**KIRKLEES COUNCIL  
TOWN AND COUNTRY PLANNING ACT 1990  
HIGHWAYS DEVELOPMENT MANAGEMENT**

**PLANNING REF** 2018/62/91661/E0/GW  
**CATEGORY** Small Major

**PROPOSAL** OUTLINE PERMISSION FOR RESIDENTIAL DEVELOPMENT AND FACILITATING ENGINEERING OPERATIONS AND FULL PLANNING PERMISSION FOR ACCESS AND SPINE ROAD

**LOCATION** LAND AT WALKLEY TERRACE AND BRUNSWICK STREET, HECKMONDWIKE

Section 8

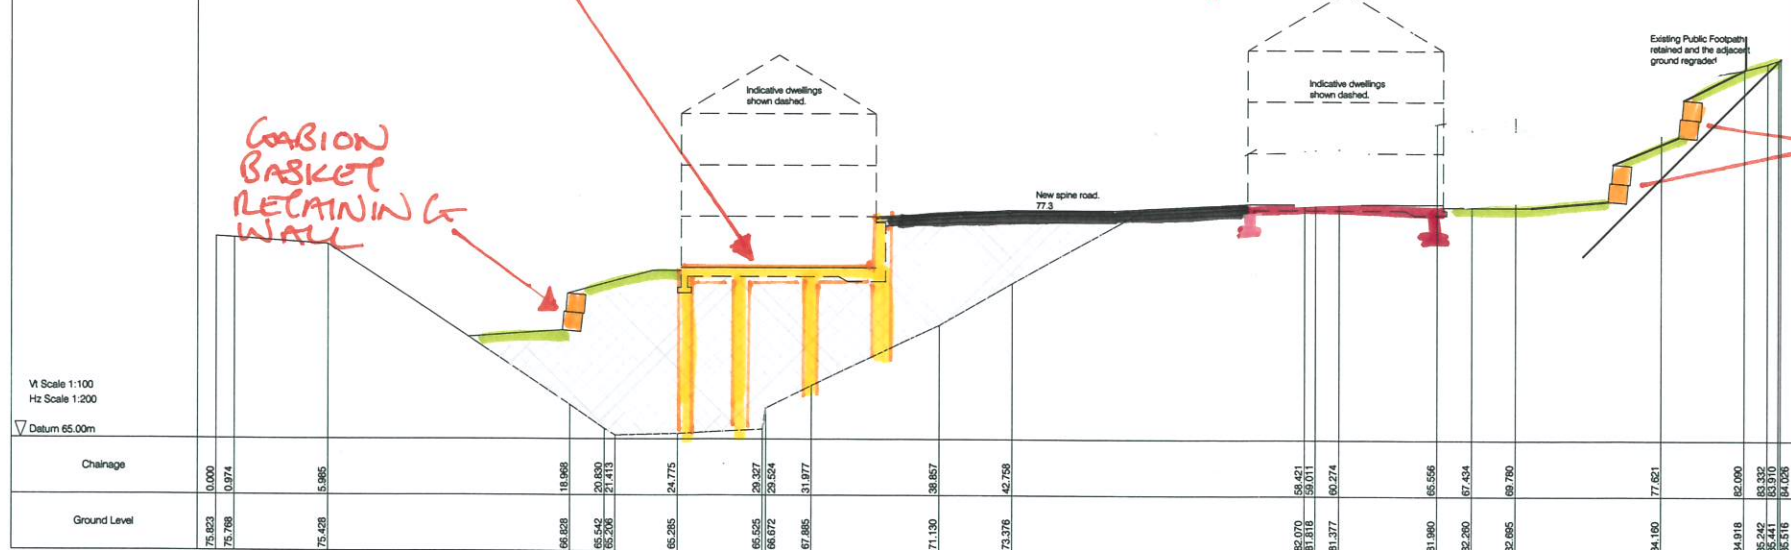
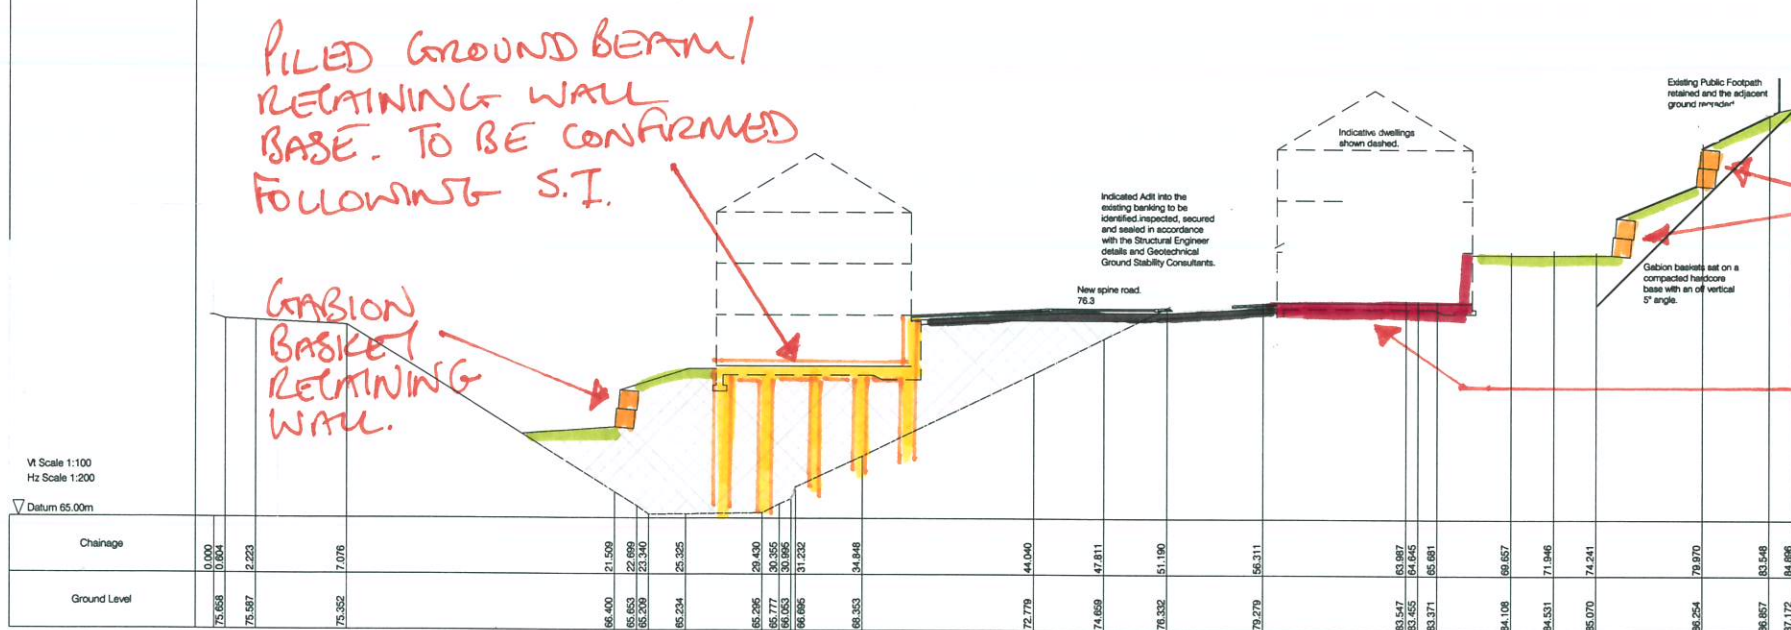
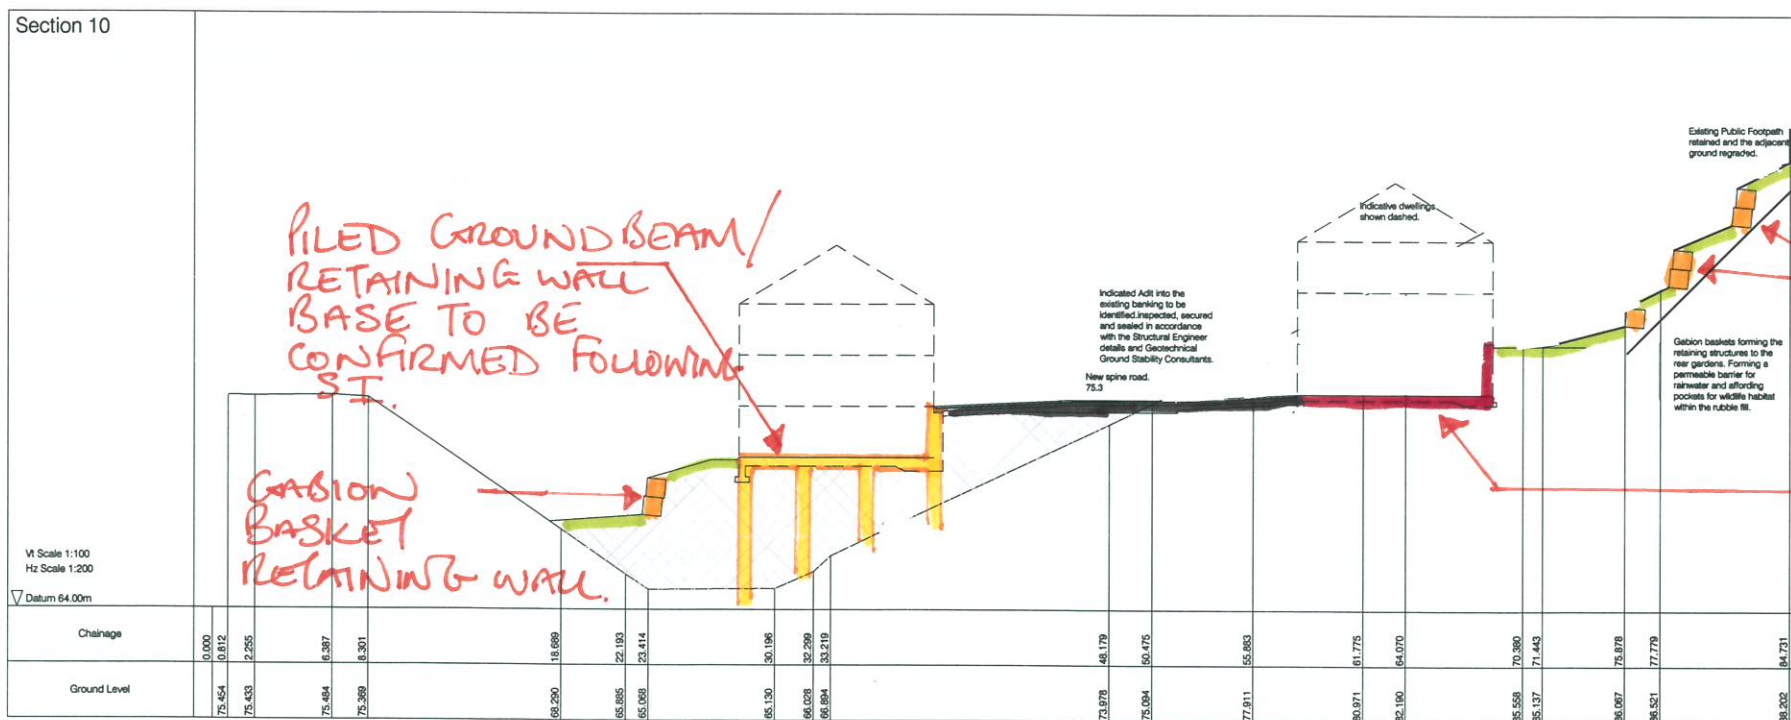
3,No chainages or gradients are shown on the longitudinal sections. The maximum acceptable gradient to a shared surface carriageway is 1 in 20. Scaling from the plans a 1 in 21 gradient is proposed. This should be confirmed and shown on the longitudinal sections.

The gradients need to be confirmed before we can make any comments regarding the greenway.
